Subject: RE: Planning Consultation on: Y/57/21/PL

Engineers Comments Regarding Surface Water Drainage

Site Address: Sunnymead North End Road Yapton BN18 0DL
Grid Reference: 498169 104354
Description of Works: Demolition of existing dwelling and outbuildings and erection of 5 dwellings comprising 2 No 4 bed houses, 3 No 3 bed house (resubmission following Y/33/20/PL). This site is in CIL Zone 3 & is CIL Liable as new dwellings.

Birdseye

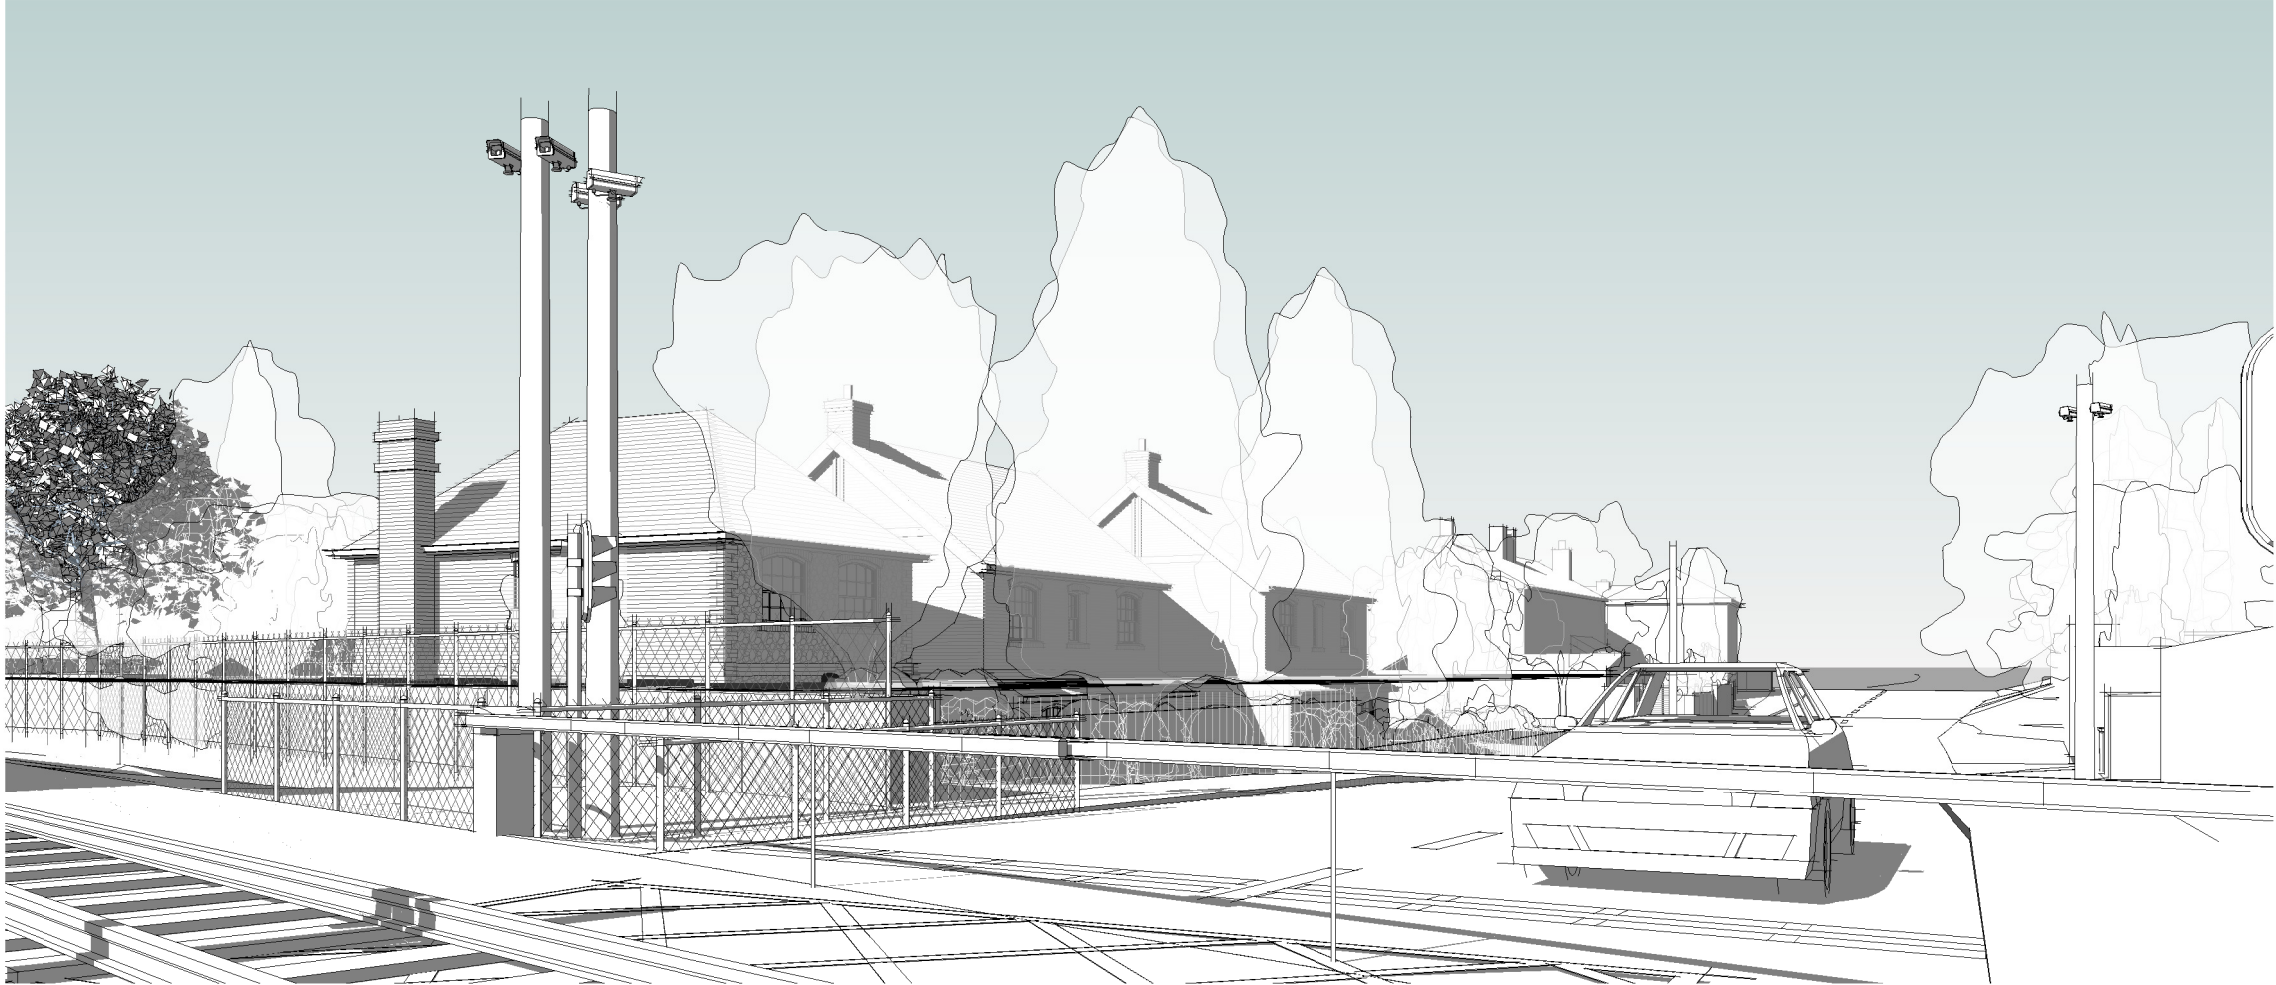
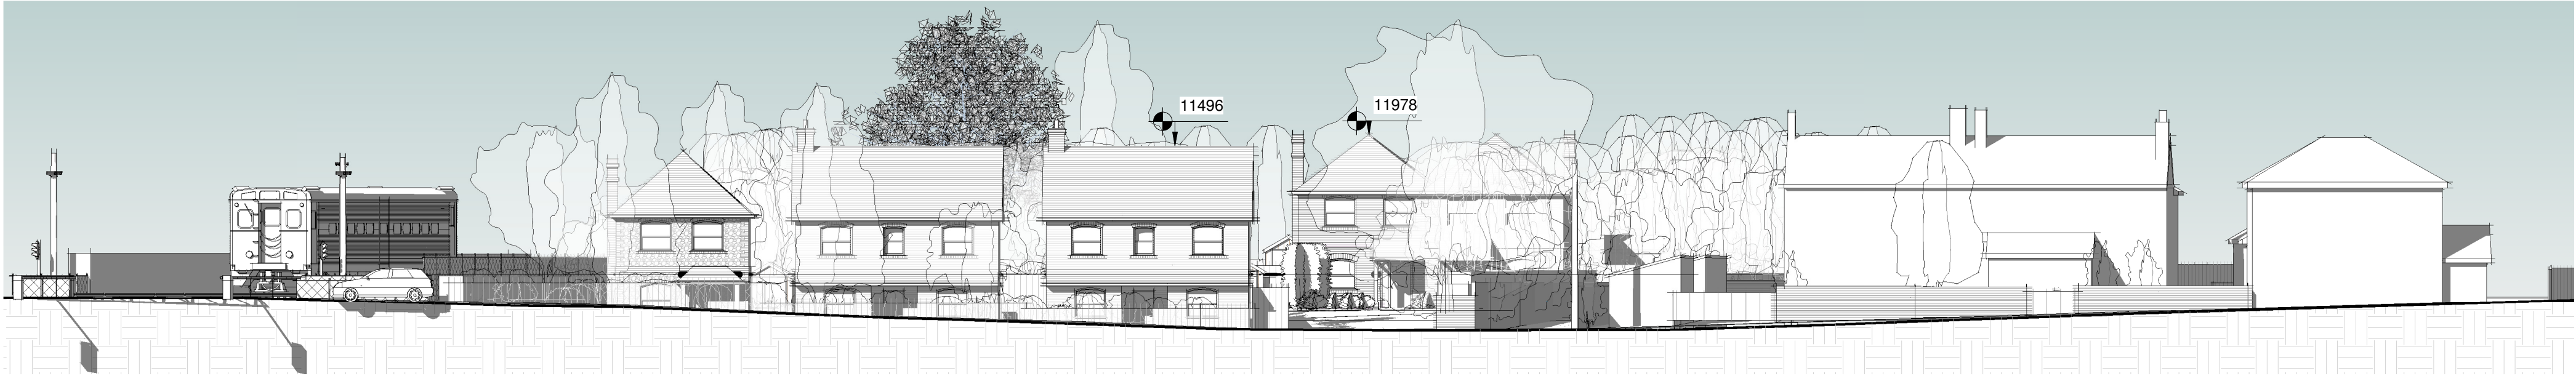
6. It is important that all the documents provided to support the application are consistent. The 3D images which have been submitted do not appear to reflect the level changes which are proposed within the Drainage Strategy Report. These should be altered to show the reality of the proposed development or removed.
